City of Albuquerque Stormwater Construction Site Inspection Report

General Information					
ESC File No.	H15E068	Project Name:	Maverik		
NPDES Id. No.		Location:	1901 Menaul blvd NE		
11/4/2020	Property Owner		Contractor		
Operator	Maverik, Inc.				
Contact name & title	Troy Jergensen				
e-mail	troy.jorgensen@maverik.com				
Contact Phone #	801-335-3851				
COA Inspector	Doug Hughes		Start/End Time:	2pm	
Construction Phase:	Earthwork				
Type of Inspection:	<input type="checkbox"/> Regular	<input type="checkbox"/> Storm Event	<input type="checkbox"/> Post Storm Event >0.25"	<input type="checkbox"/> 311/Complaint	<input type="checkbox"/> Follow Up
Weather at time of inspection?	Clear		Temperature: ~	76	
Estimated date of last storm 0.25" or greater

ENGINEER'S SEAL	MAVERIK UNIVERSITY AND MENAUL	DRAWN BY VP
		SWPPP LAYOUT AND ESC PLAN 1	DATE 1/6/2020
		TERRA WEST, LLC 5571 MIDWAY PARK PLACE NE ALBUQUERQUE, NM 87109 (505) 858-3100 www.tierrawestllc.com	2018062-SWPPP
			SHEET # SW1 JOB # 2018062

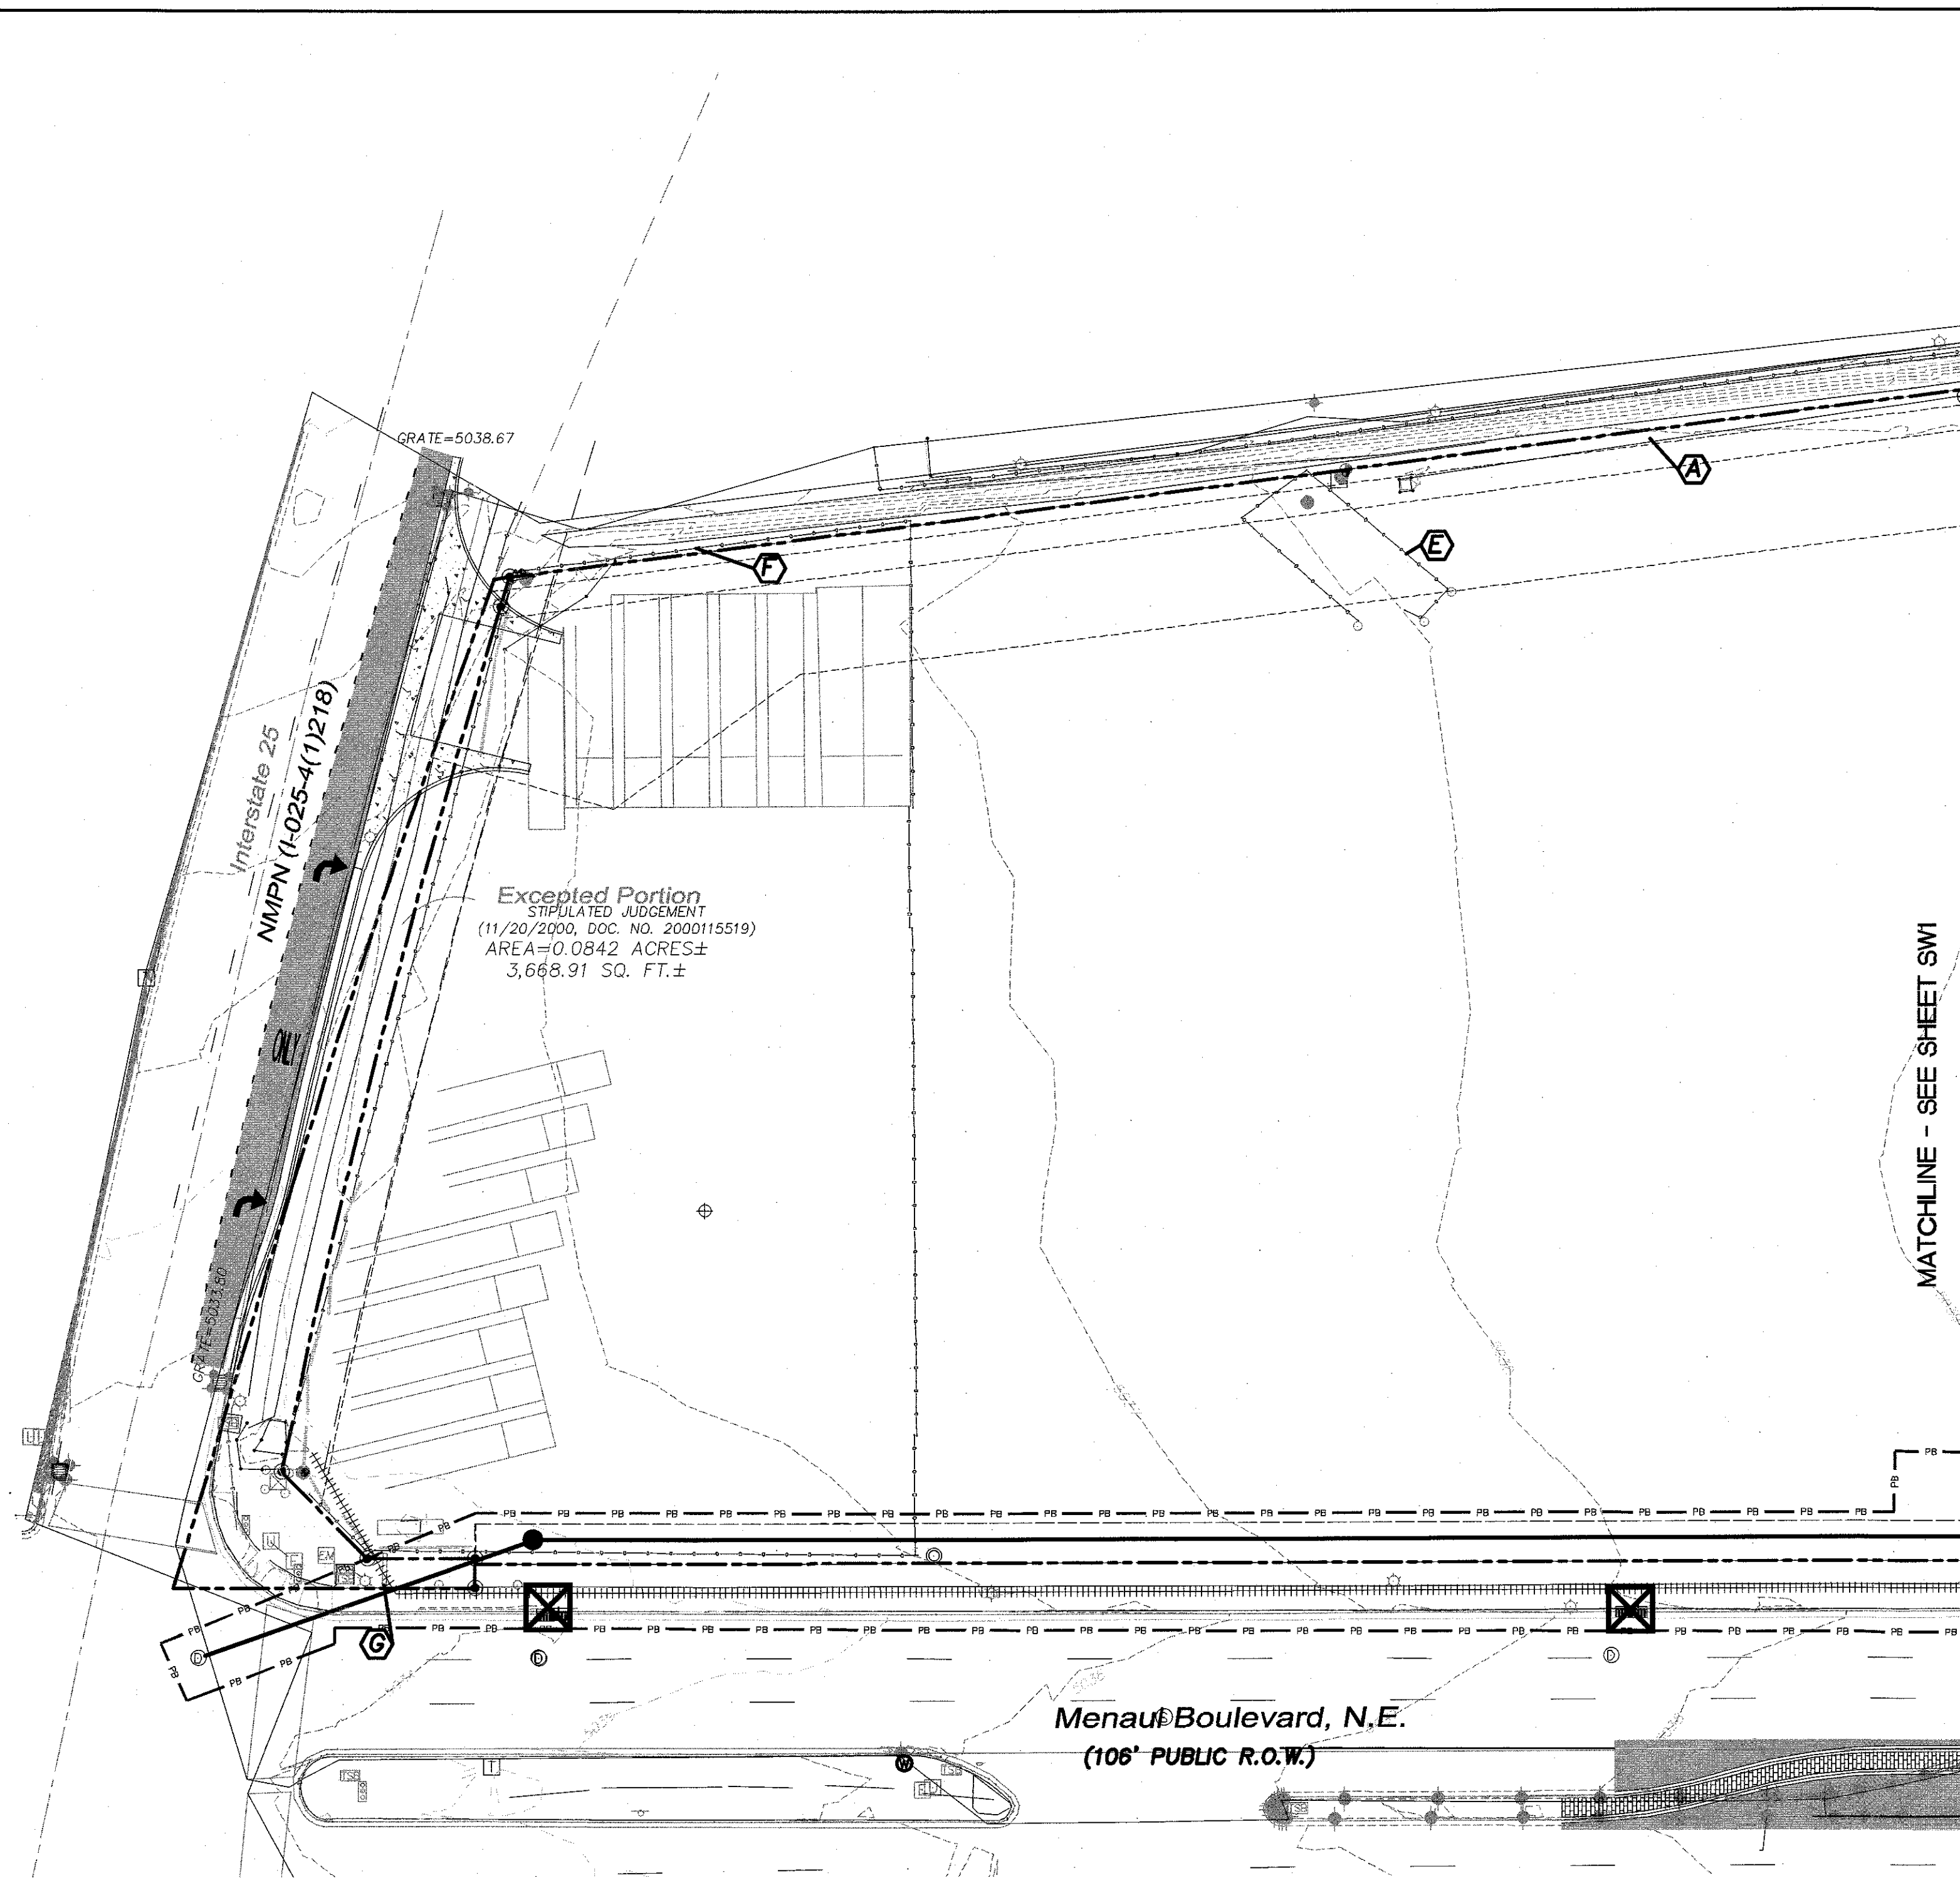
Item Number	Deficiency/ Corrective Action				
1	Silt fence not embedded and big gap (inpromptu entrance) at low point. Abandon the entrance in low corner and never have another hole in the silt fence again so long as this project lasts. Silt fence embedment is 12" minimum and faberik is 4' high per detail on approved plan.				
2	Construction debris not in acceptable container				
3	Inlet protection (sandbags around perimeter) three inlets in menaul in low corner.				
4	The ponds in the low corner are missing. See approved plan. It is supposed to be the first item of earthwork construction.				
5	Sediment in Menaul at inpromptu entrance and at c&g Construction must be removed daily.				
6	Where is the SWPPP?				
7	Provide SI contact info.
